**From:** Bennett, Richard - Communities  
**Sent:** 22 July 2019 12:59  
**To:** Michael Smith; Beaumont, John - Communities  
**Cc:** Drainage - E&E; White, Joy - Communities  
**Subject:** RE: Request for Comments on Proposed SW Strategy for Development  
**Attachments:** 05-Drainage schedule.docx

**Richard Bennett**  
**Flood Risk Engineer**  
**Oxfordshire County Council**  
**County Hall**  
**New Road**  
**Oxford**  
**OX1 1ND**

**Figure 4-2: Site Wide Existing Drainage Network**

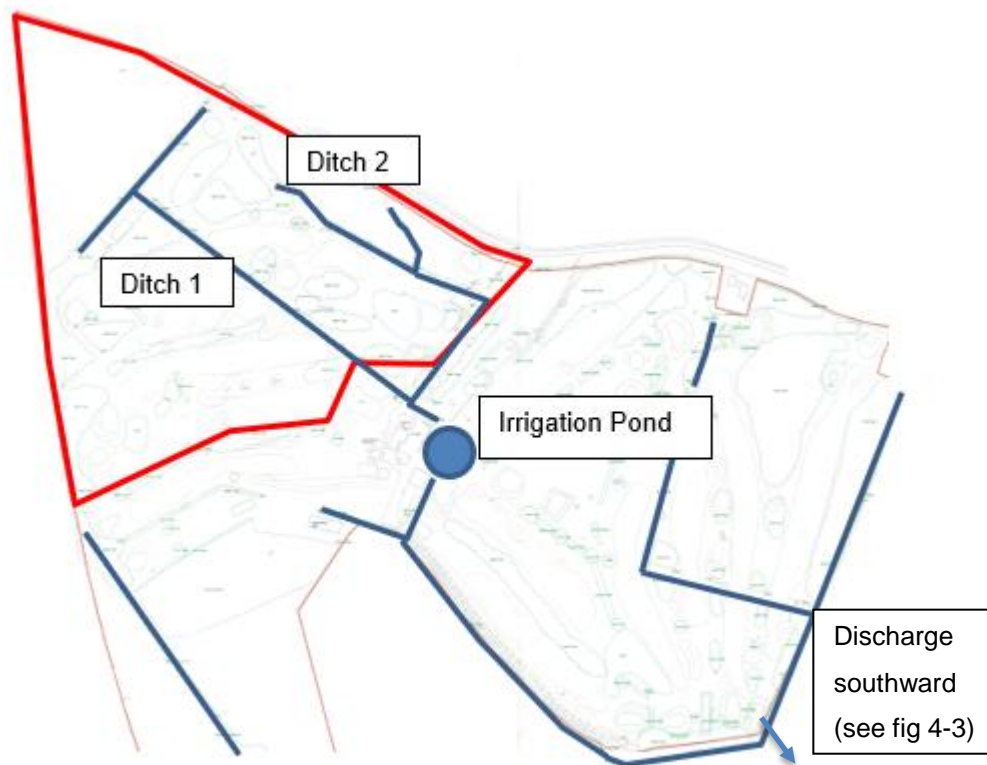
At the moment we have concerns that the layout is not allowing adequate space for above grounds SuDS and we see that existing drainage features are proposed to be removed which the LLFA cannot support.
